OFFICIAL NOTIFICATION OF DECISION

Project# PR-2021-005984
Application#
SI-2022-00269 PRELIMINARY/FINAL PLAT

For all or a portion of: **LOT B-1, LOT A-1 & LOT 11 BLOCK 9, RIDGE PARK ADDITION** zoned **MX-L**, located at **2109-2111 SAN MATEO BLVD NE between INDIAN SCHOOL NE and HAINES NE** containing approximately **0.4017** acre(s). **(J-17)**

**PLAT OF
LOT "A-1", "B-1-A" AND 11-A, BLOCK 9
RIDGE PARK ADDITION**

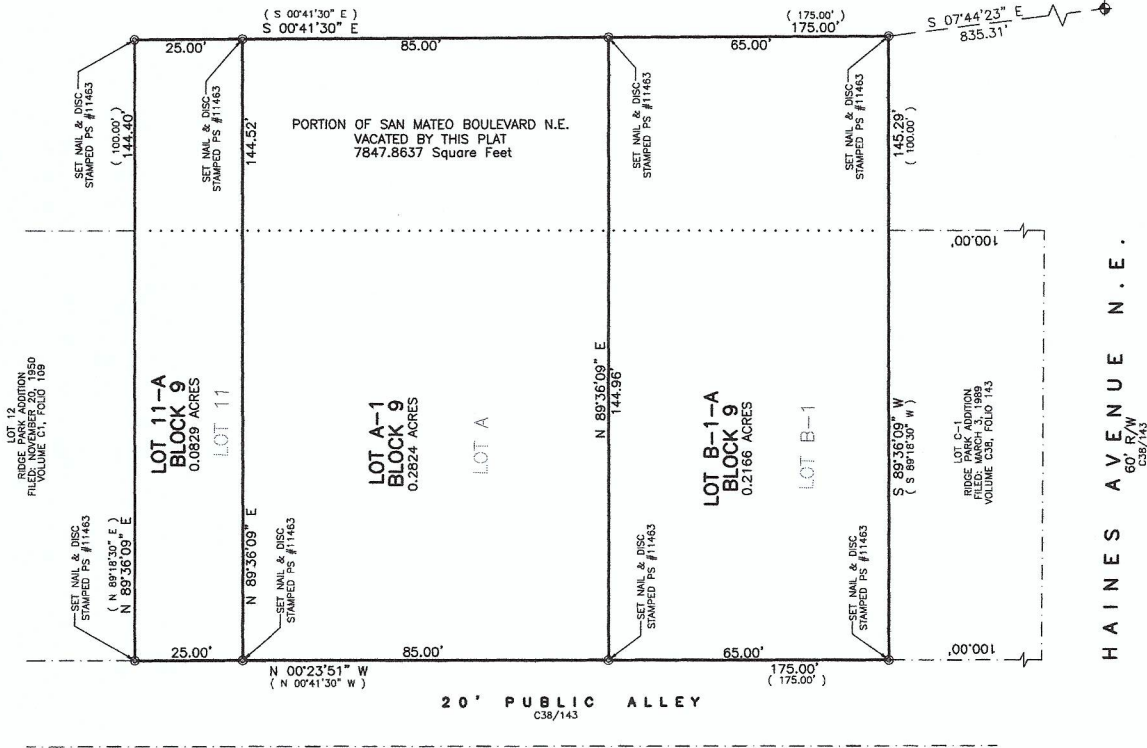
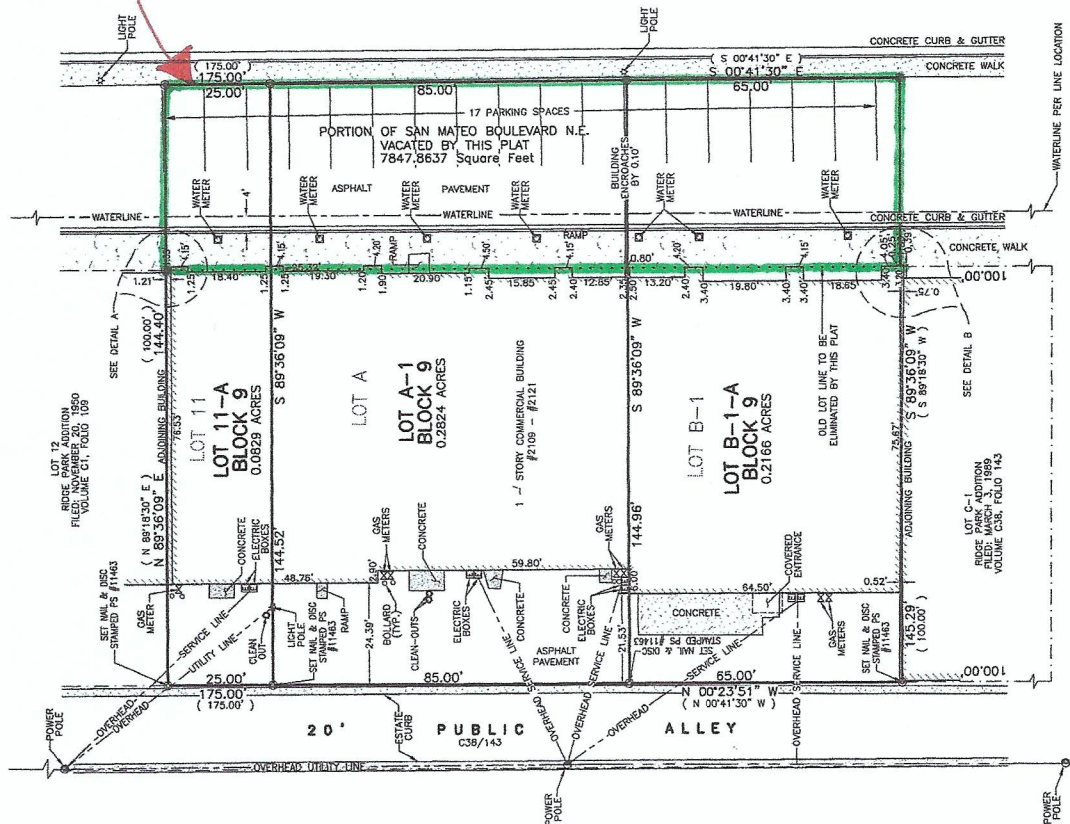
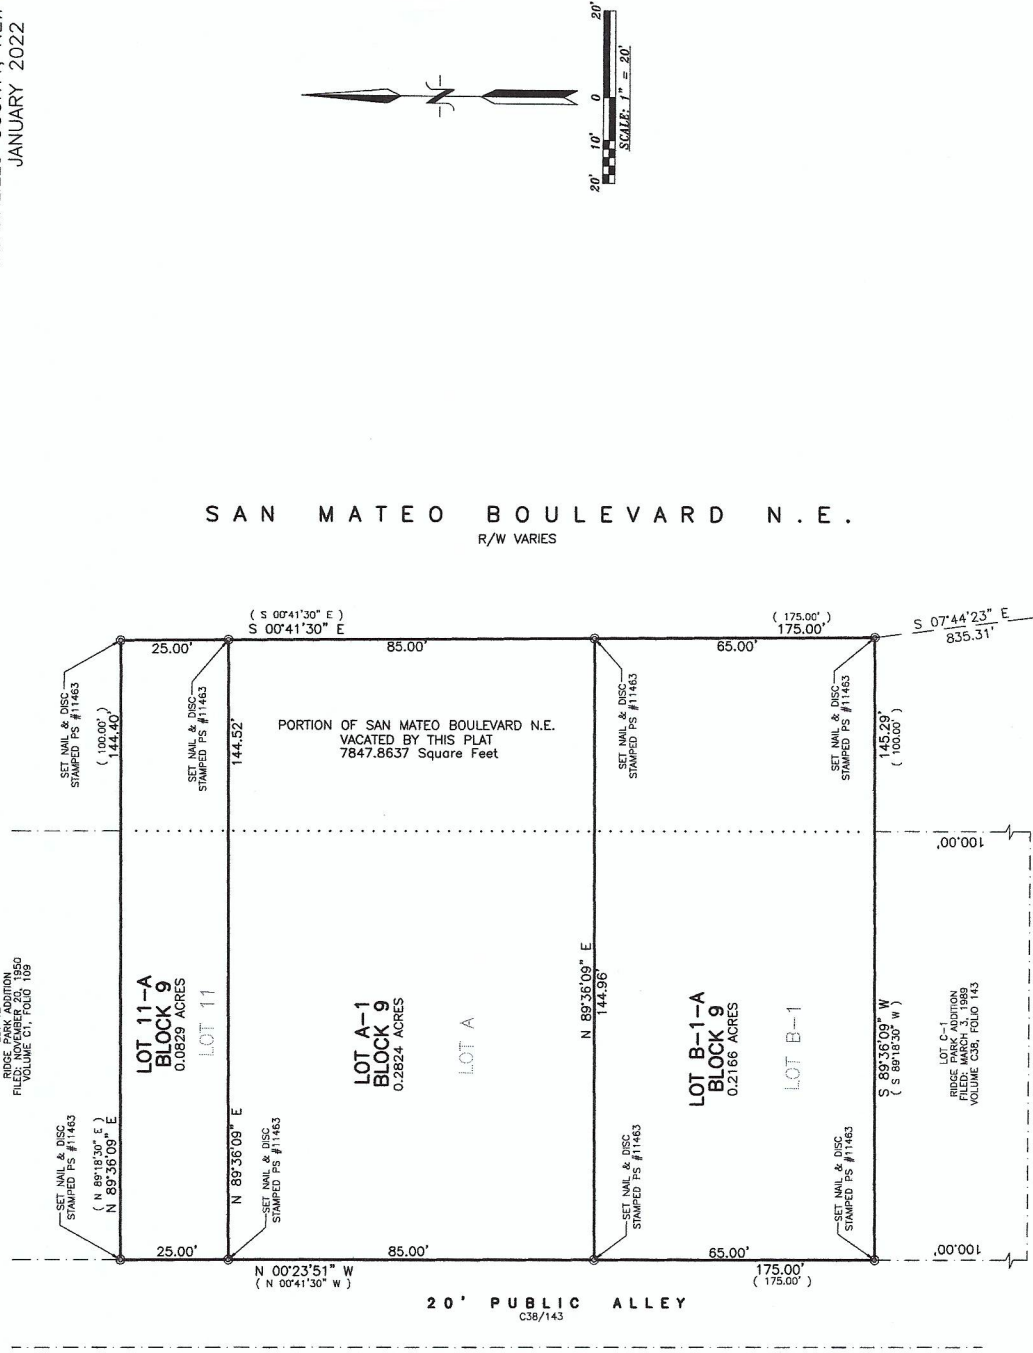
1. Final sign-off is delegated to ABCWUA for review of an exhibit showing waterline and easement locations.
2. Final sign-off is delegated to Hydrology for a cross-lot drainage easement note.
3. Final sign-off is delegated to Planning for the application number to be added to the Plat and for the AGIS DXF file.
4. The applicant will obtain final sign off from ABCWUA, Hydrology, and Planning by January 18, 2022 or the case may be scheduled for the next DRB hearing and could be denied per the DRB Rules of Procedure.
